CITY OF ALBUQUERQUE

June 15, 2017

**Re: The Shoppes at Ellison
Erosion and Sediment Control Plan
Engineer's Stamp Date 6-13-17 (A14E010E)**

Erosion Sediment Control Plan

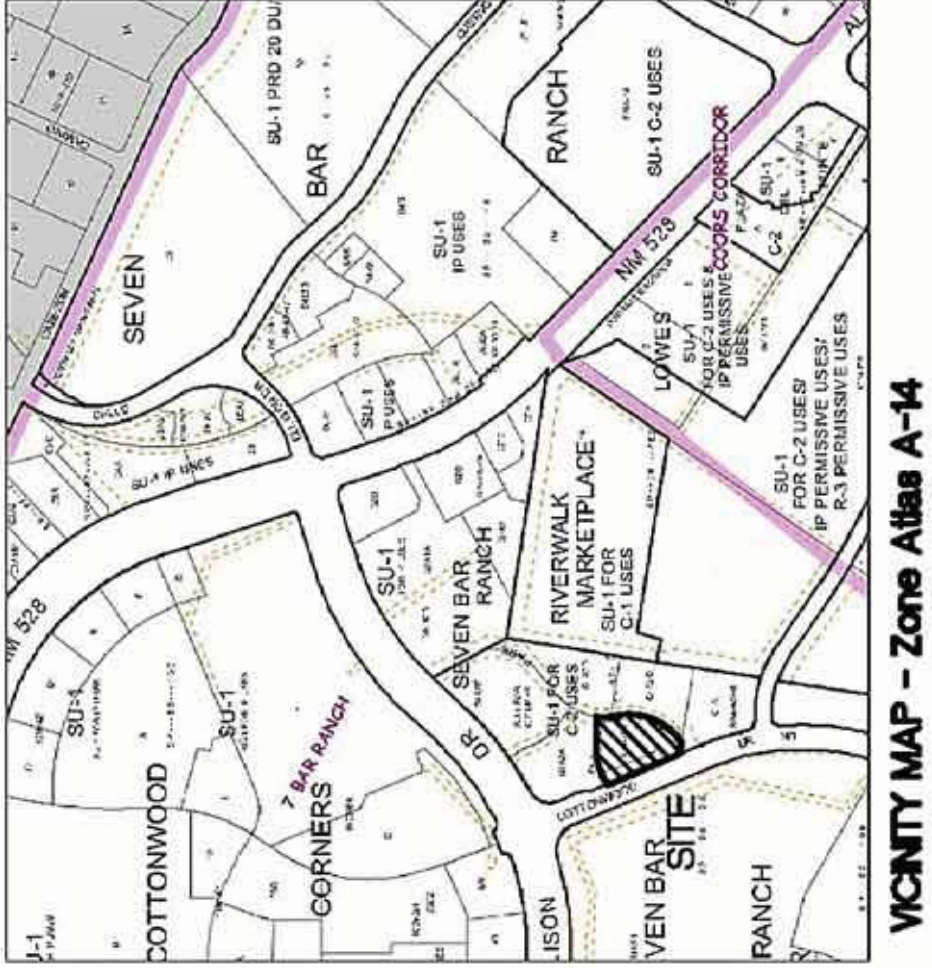
If the saw-cut along the northern boundary does not occur or is not effective in reducing sediment from migrating off the site a sediment BMP will be required.
